06 November 2020

Our ref: 202007_003

RE: SSD-10371 Trinity Grammar School redevelopment – Response to Submissions – Transport and Access comments

Figure 3. Proposed new bike parking location (Source: PMDL, 2020)

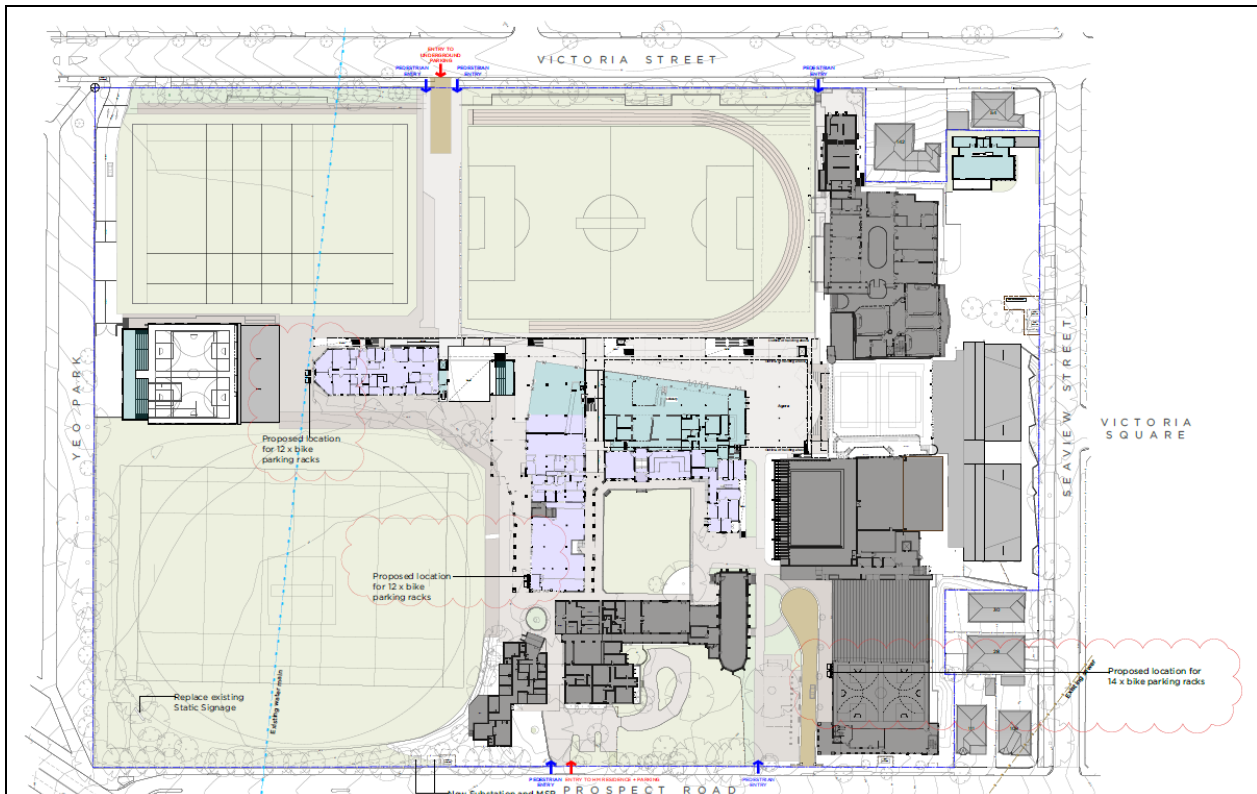
“It is unclear whether bicycle parking spaces with end of trip facilities are provided on site. Adequate bicycle spaces with end-of-trip facilities should be proposed and identified in the architectural plans.”

However, on further assessment, this location for the bike parking is not ideal given that bike riders will need to mix with the car park traffic to access the bike parking. The alternate is to enter the school at ground level, dismount, and walk the bike to the bike parking. These actions are likely to be a disincentive to bike riding.

It is proposed to relocate the bike parking so that it is accessible from Prospect Road and closer to the end of trip facilities in the aquatic centre. Three potential locations are proposed, with final placement (or potential to consolidate these options into one or two locations) to be decided during detailed design.
